**HUNNINGLEY CLOSE, STAIRFOOT.**

**BIODIVERSITY NET GAIN REPORT.**

**Ref No: 250351.**

**Date: 3<sup>rd</sup> April 2025.**

PROJECT	Residential Development
CLIENT	Mr. Dave Gill
TITLE	Site Layout
ADDRESS	off Hunningley Close, Stairfoot, Barnsley. S70 3PH
DRAWN BY	999
SCALE	1:200 @ A3 DATE Mar 25
DRAWING No	514-02 REV B

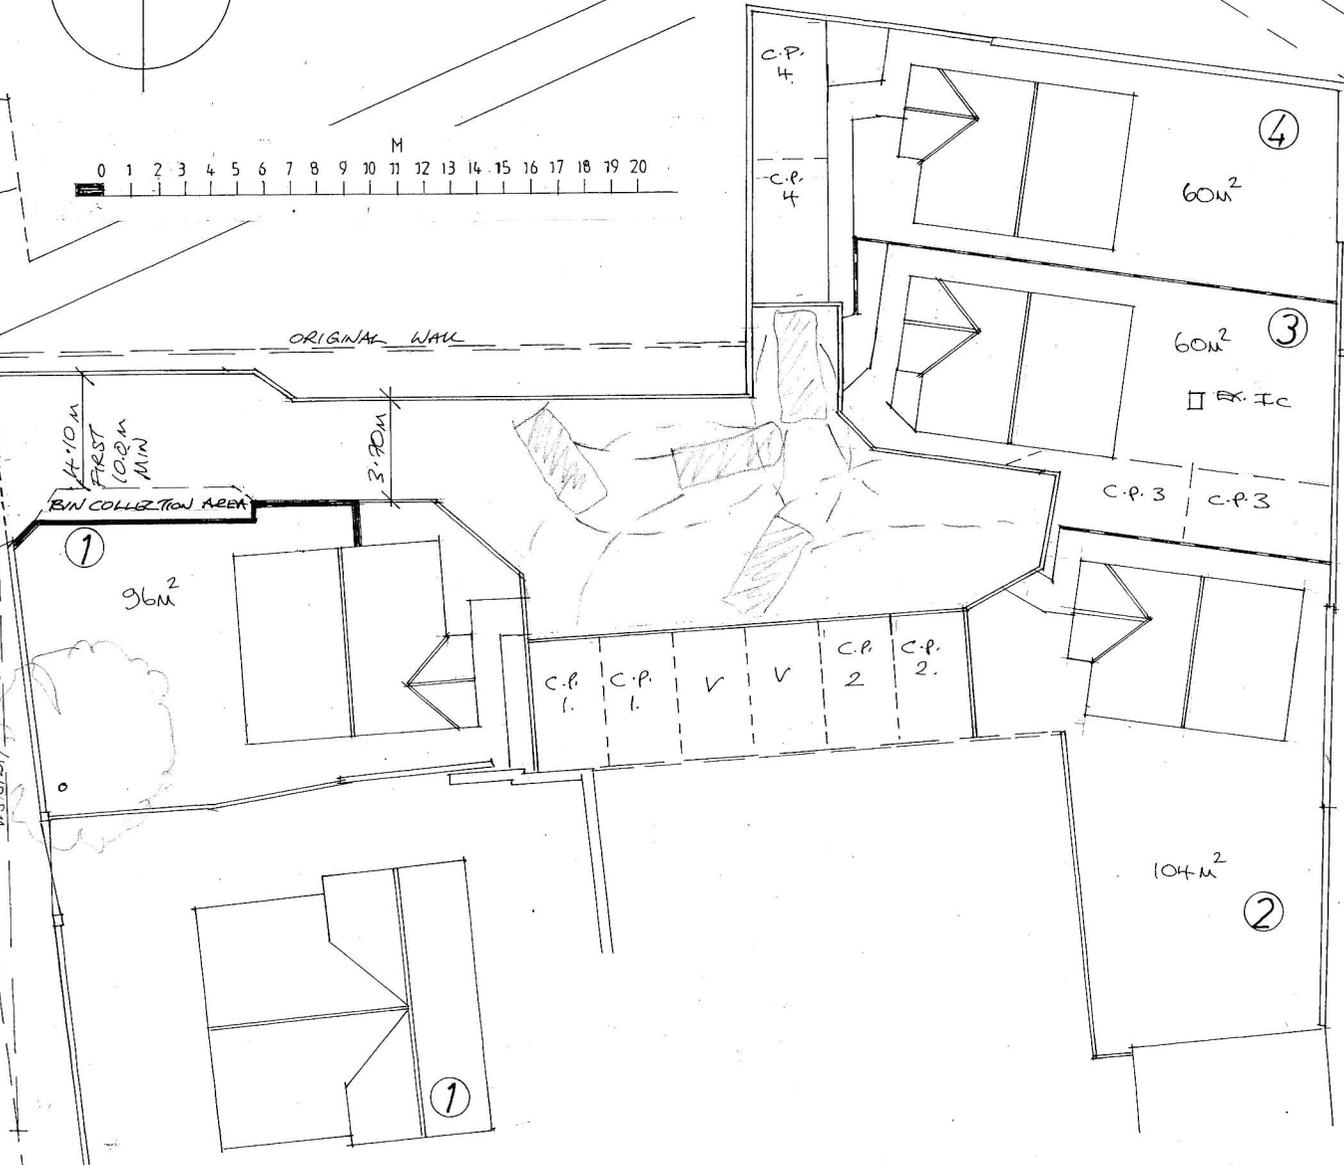
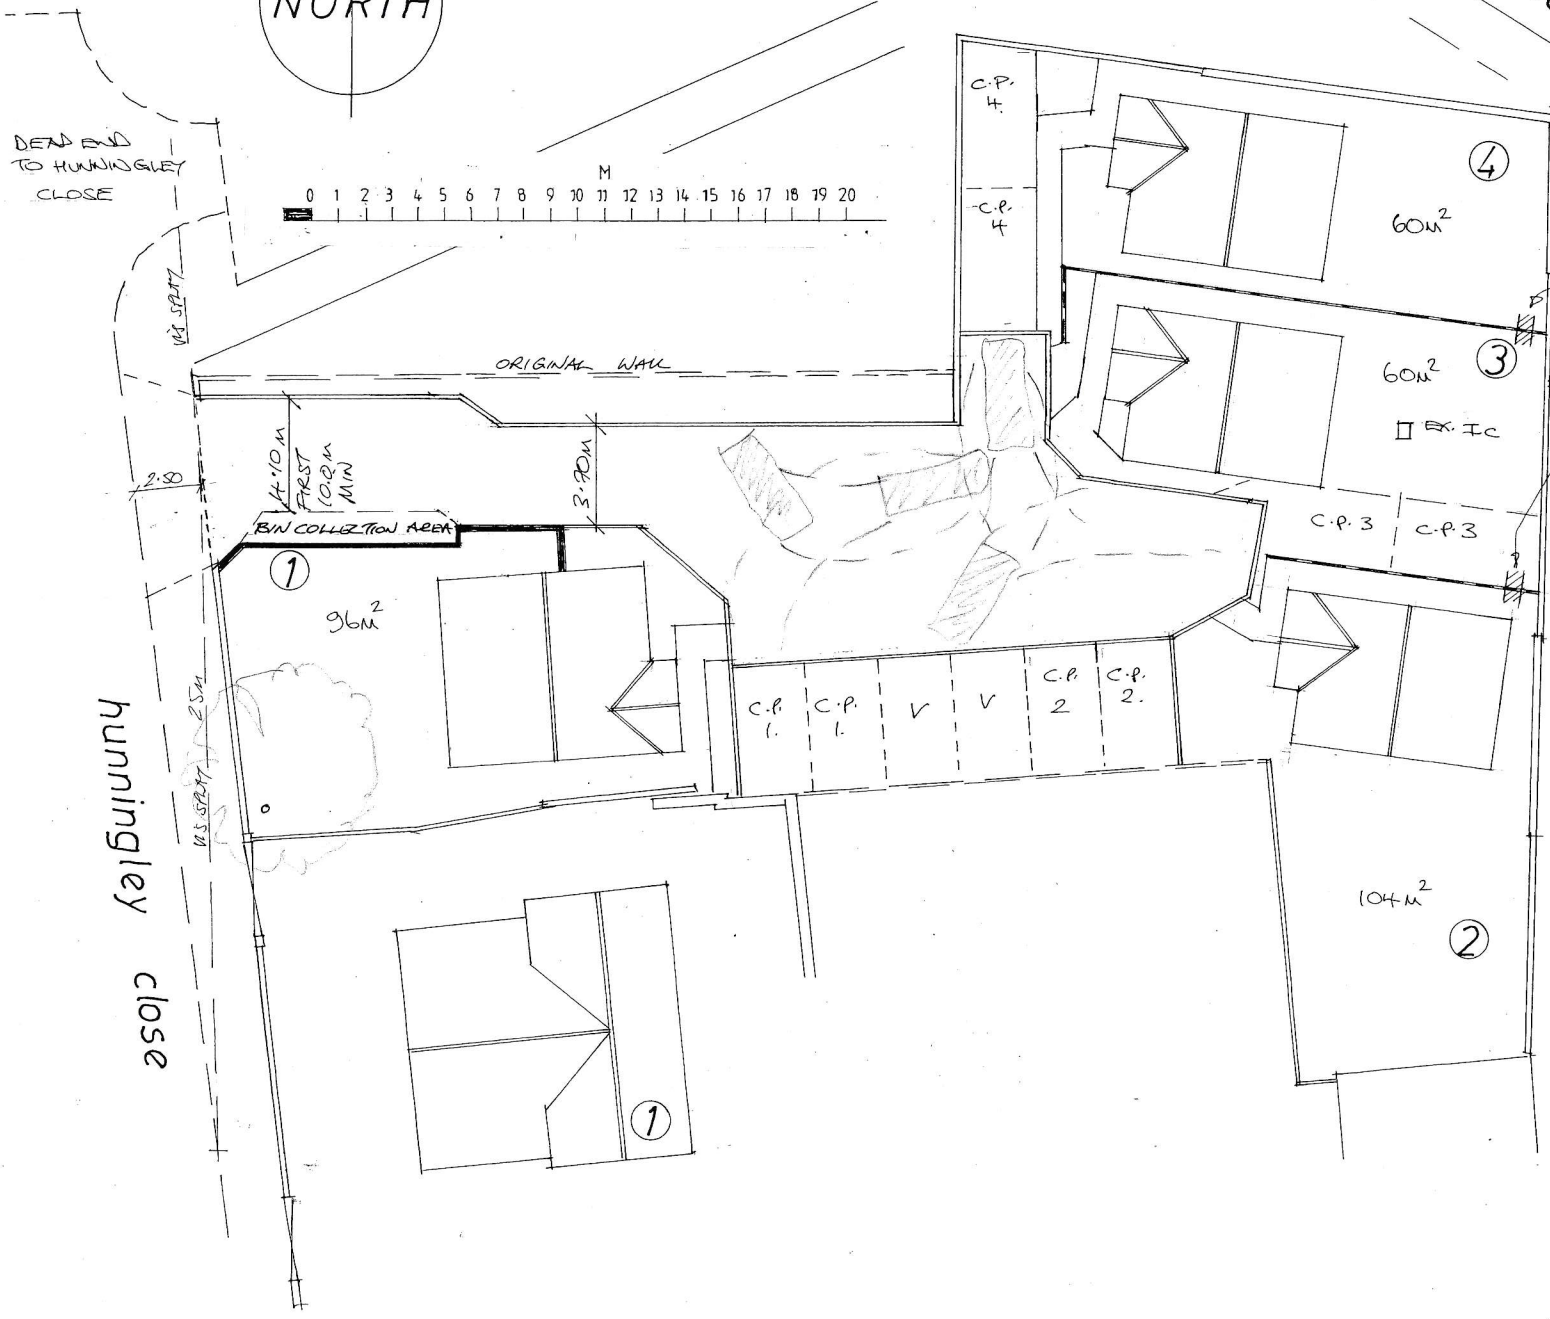
4.3.1. There has been the loss of scrub and trees within the survey area already. The proposed layout plan shows no retained habitats and the existing horse chestnut tree is indicated to be removed. There will be sealed surface and vegetated gardens as the created habitats.

6.1.2. To help achieve a net gain, as recommended above, in the first instance it in line with the mitigation hierarchy, is recommended that the chestnut tree is retained. This is especially important in this case as it is assessed as irreplaceable habitat and will require bespoke compensation if it is to be lost or the condition is degraded. Therefore it is recommended that some retained greenspace is incorporated into the development around this tree. Consideration should also be given to enhancing retained habitats where possible.

6.4.4. Hedgehog access points, at least 13cm x 13cm, should also be installed at various points in any new boundary fences. This will also allow for the access and egress of the mammals already utilising the site.

PROJECT	Residential Development	
CLIENT	Mr. Dave Gill	
TITLE	Plot 2 Elevations	
ADDRESS	off Hunningley Close, Stairfoot, Barnsley. S70 3PH	
DRAWN BY	999	
SCALE	1:100 @ A3	DATE Mar 25
DRAWING No	514-08	REV A

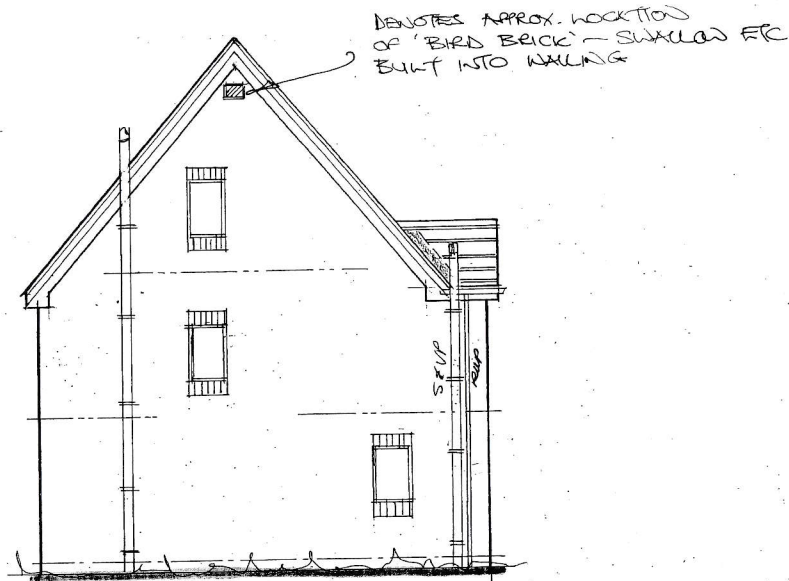
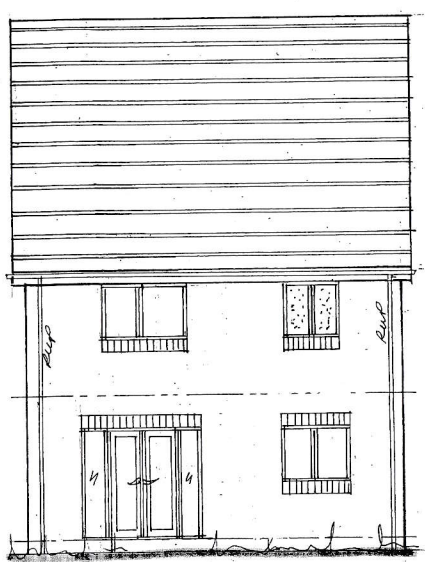
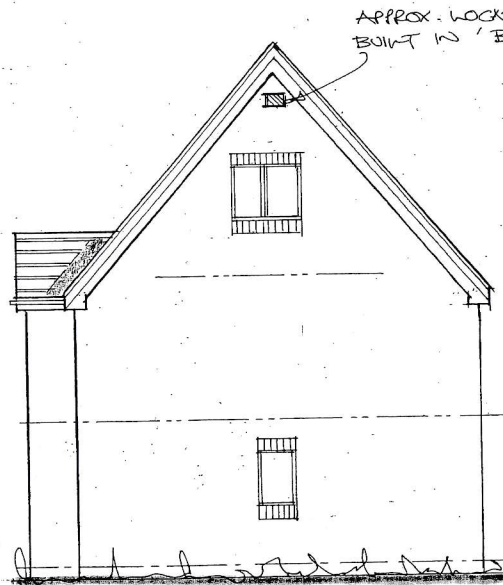
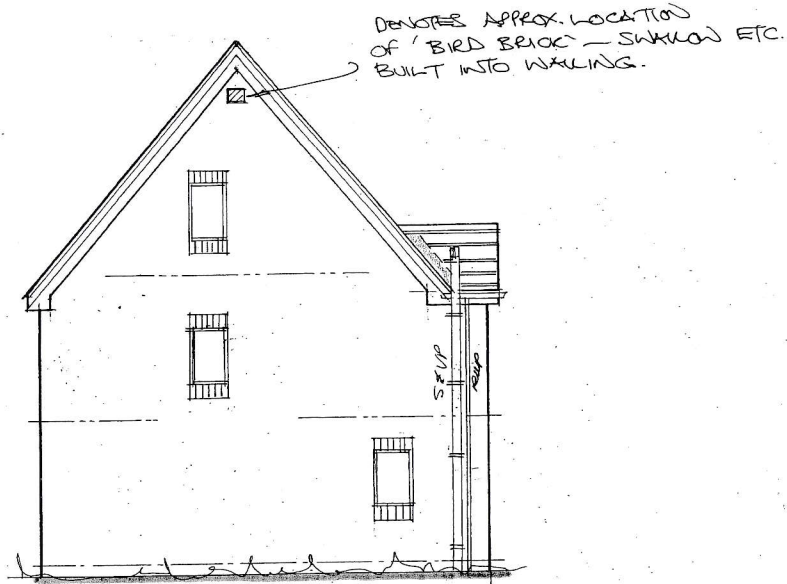
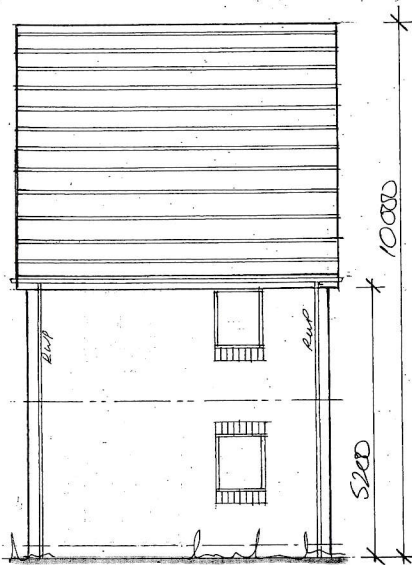
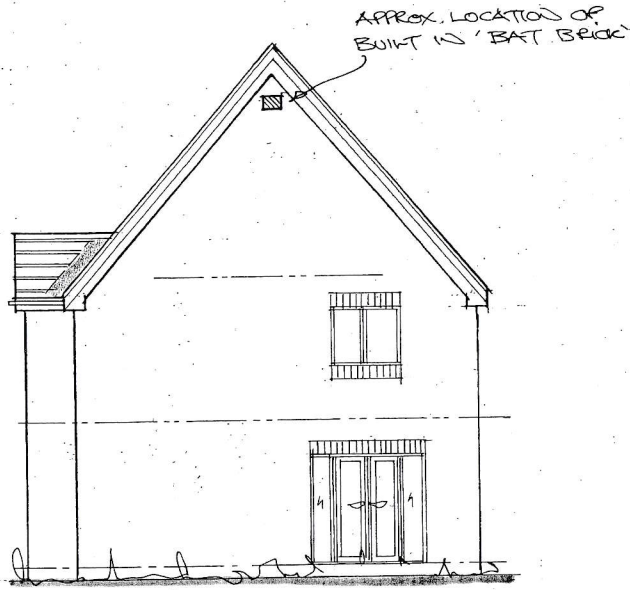
6.4.2. It is therefore recommended that 50% of the buildings includes an integrated bat box as shown below, or equivalent. This can be ordered to match the outer skin of the new building and should be incorporated high in a gable end wall (if possible) where it is not over a door or window.

6.4.3. It is also recommended that a pair of integrated swift boxes are installed 50% of the buildings. The example below or equivalent should be used.

6.4.5. It is recommended that one bee brick is built into an external wall of each of the proposed properties.
